Subject: RE: Y/105/19/PL and Y/106/19/L

Following our telephone conversation in April and previous email correspondence regarding the planning and listed building application for Stakers Farm Barns, we are intending to make the following amendments to the application to secure a positive determination:

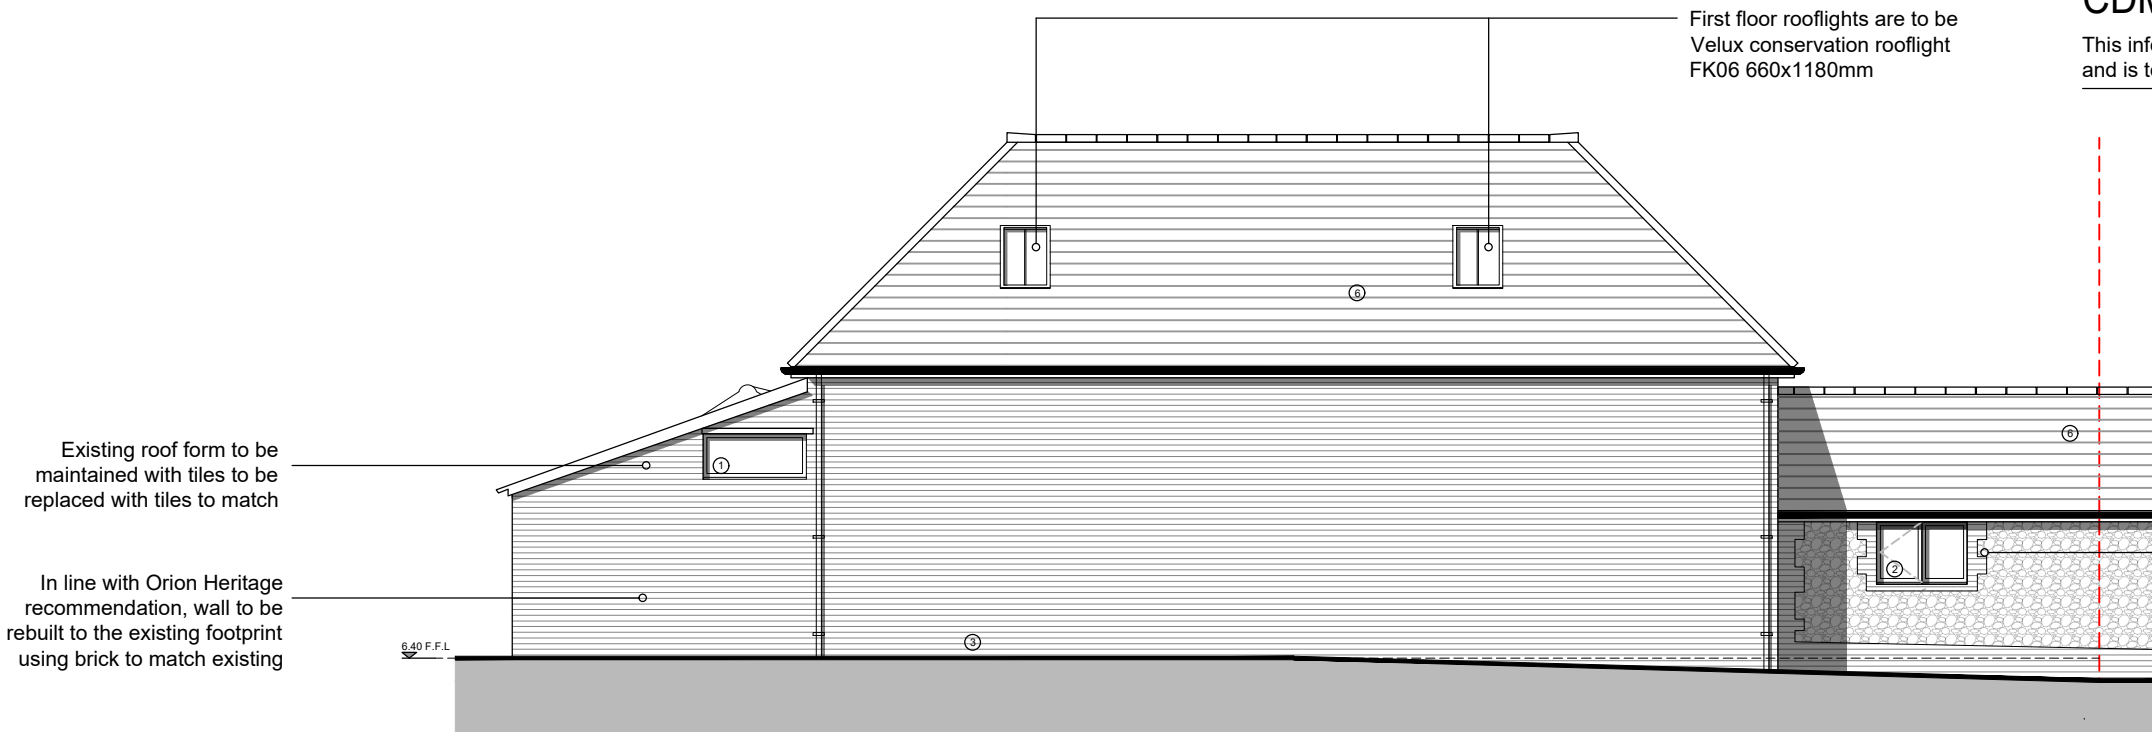
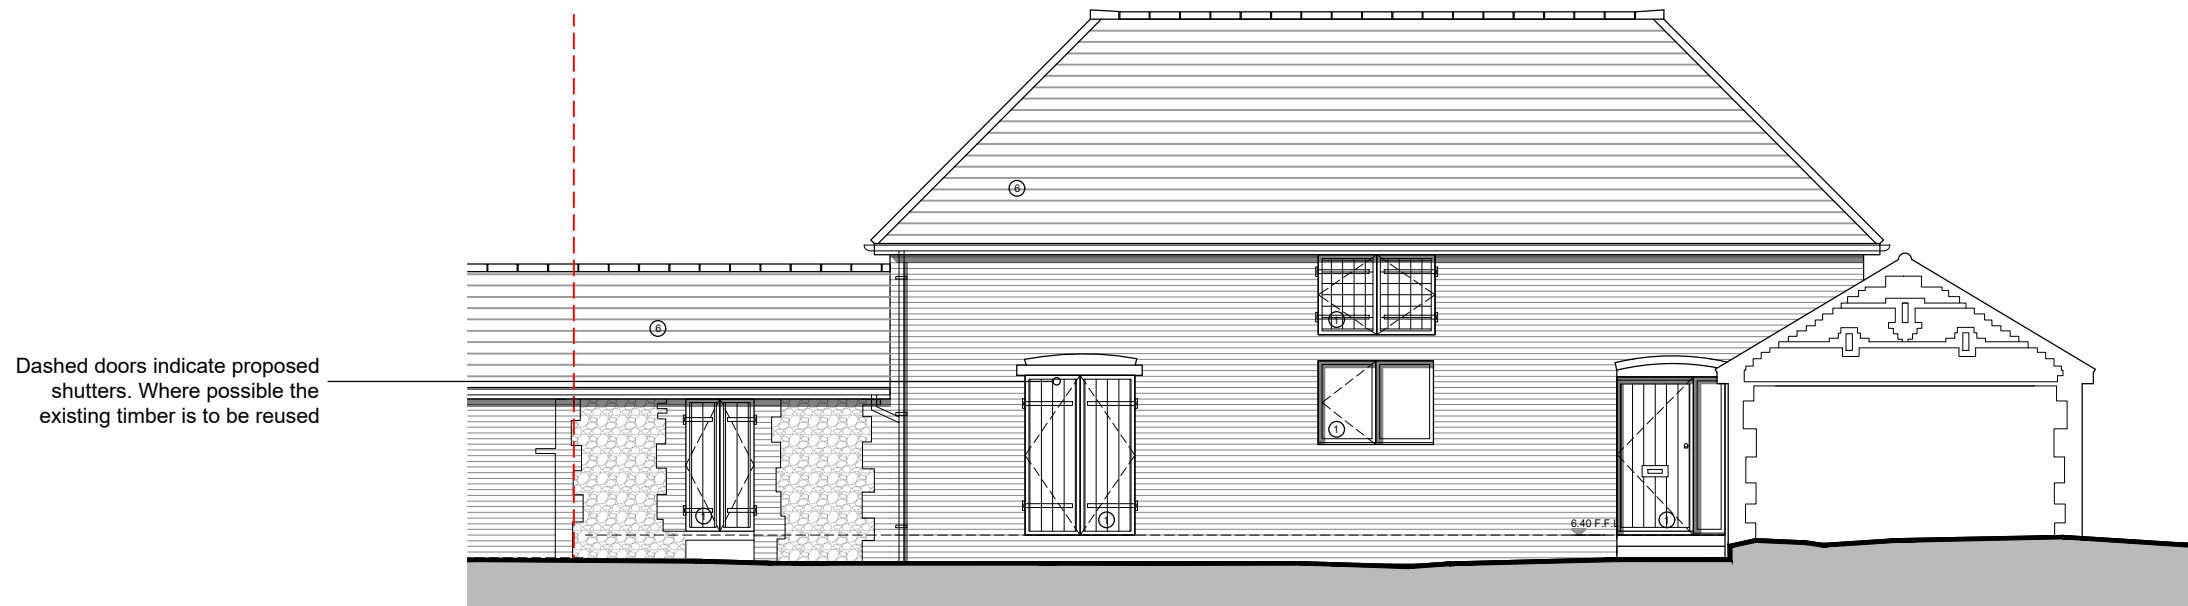
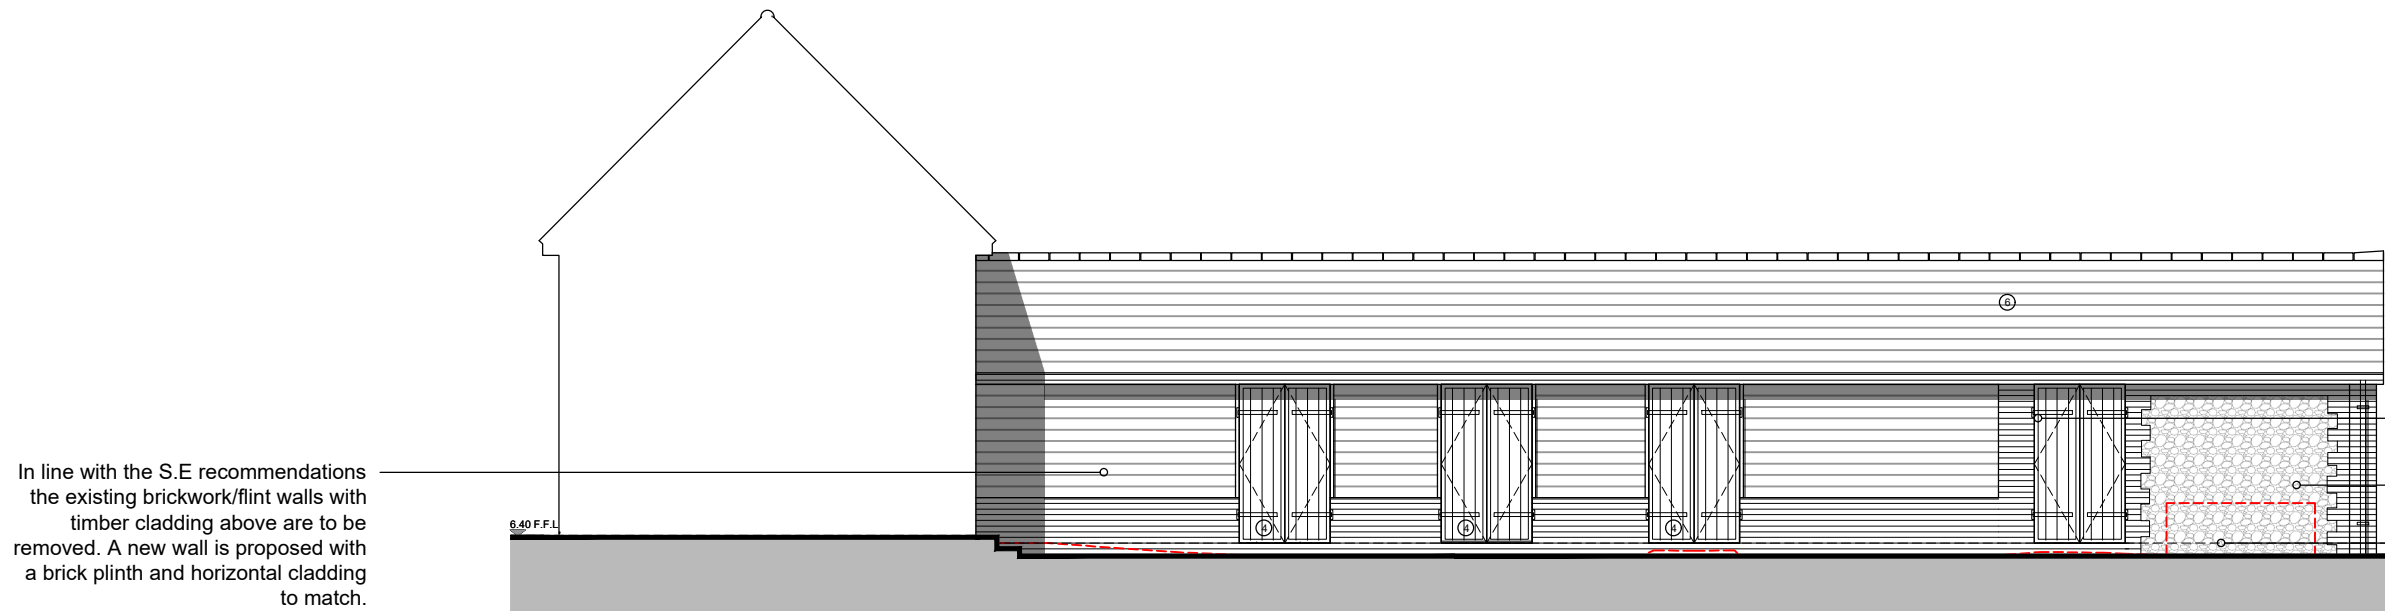
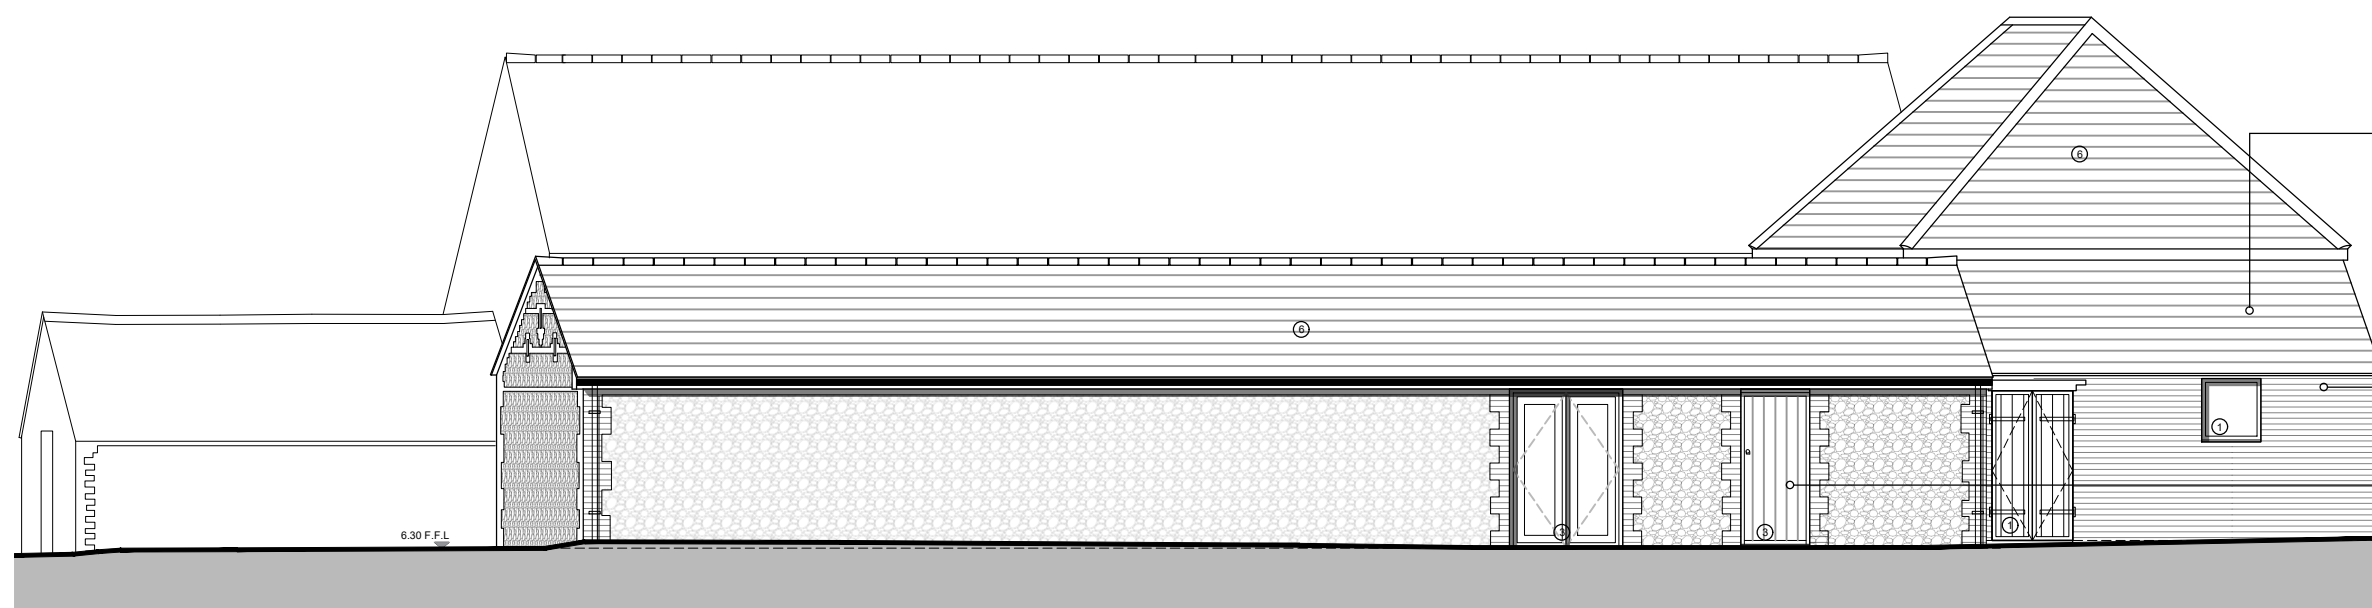
Barn 1

We will remove as many rooflights as possible from this barn. However, we cannot remove all the rooflights as we will need to provide light to the bedroom to make it a habitable space. A roof light will also be required to provide purge ventilation (Part F of Building Regs) otherwise a mechanical system would be needed. Under the Building Regulations we will also need to meet the Daylight and room brightness guidance set within British Standard BS 8206-2:2008 Lighting for Buildings. We will therefore seek to provide the very minimum amount of rooflights necessary to meet Building Regulations and seek to locate them on the least prominent part of the roof.

South elevation – we will amend the proposed alterations to the single storey element and reduce the amount of glazing, ensuring that this elevation is changed as little as possible from the existing situation.

Proposed East Elevation (B)

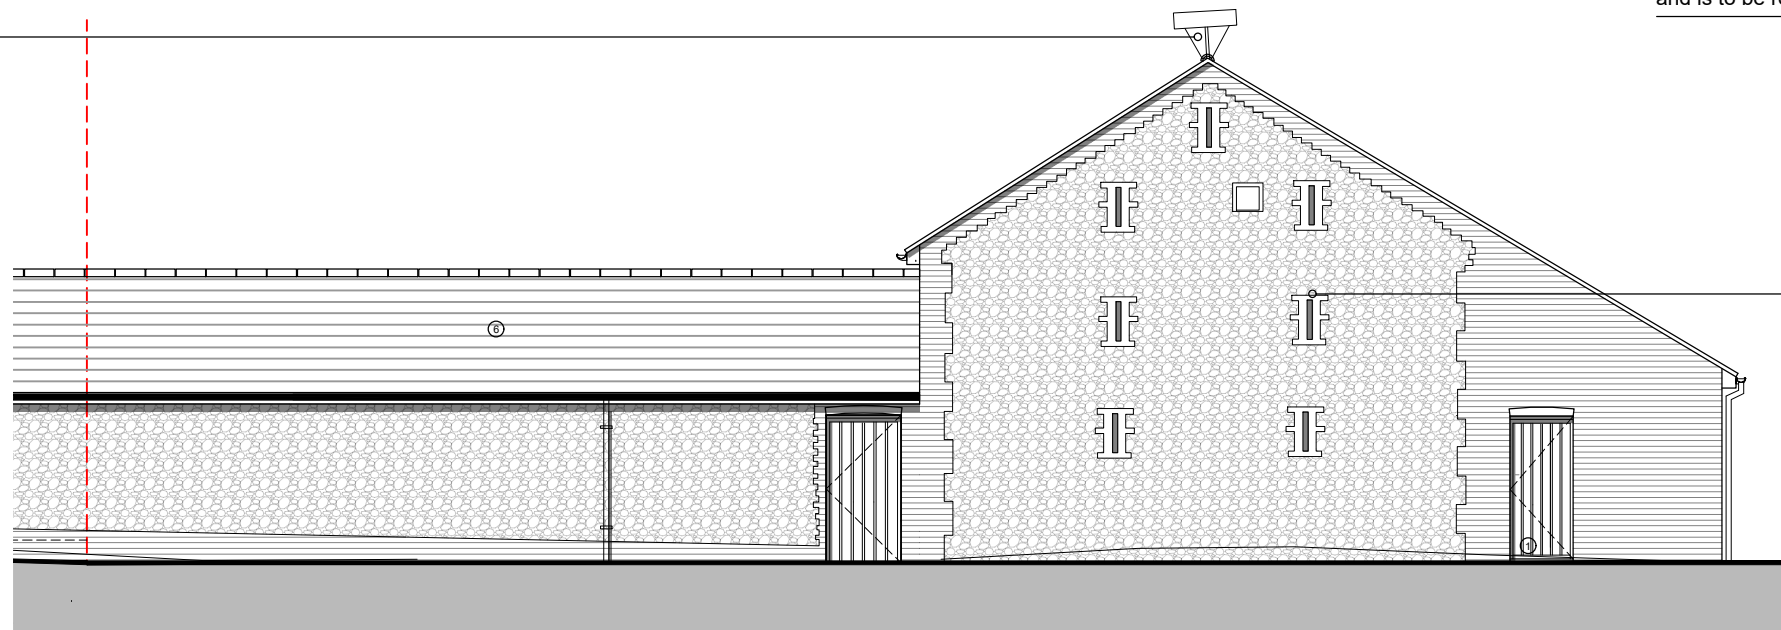
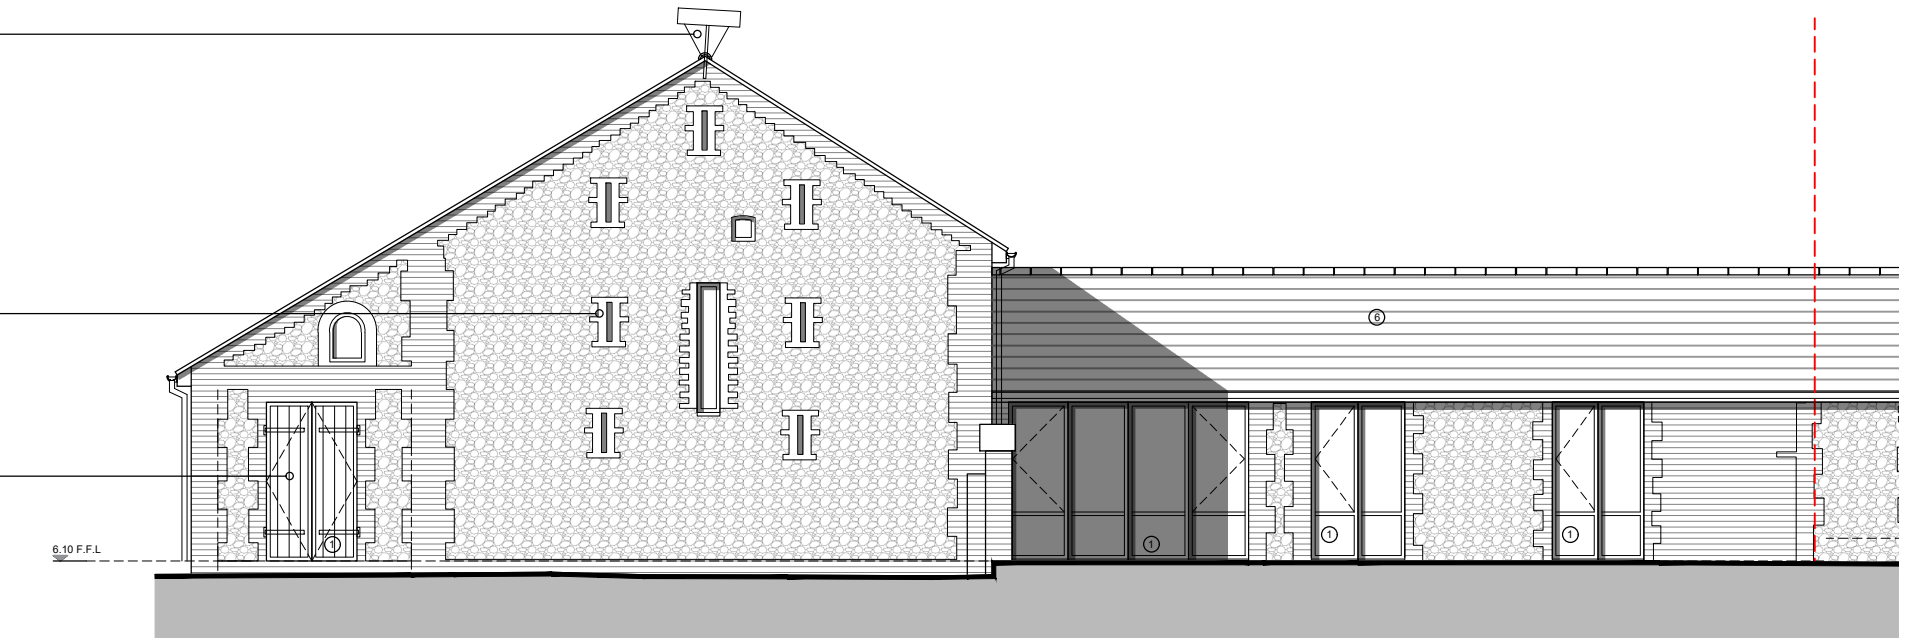
East elevation – we will ensure that the single storey element of the barn retains the features of the existing building as far as possible and will not reduce in size the larger existing opening.

East elevation – having regard to the two storey part of the barn, as discussed, we will have a look at how we can improve that part of the barn that was rebuilt at a later date and we will replace the existing unsympathetic door.

South elevation – we will remove all of the lower rooflights but will keep the higher ones. We will also reconsider the French doors.

North elevation – we will reduce the number of rooflights as agreed

North-west elevation – we will seek to retain the small existing window by the door and retain the existing door in the single storey element rather than installing a new door.
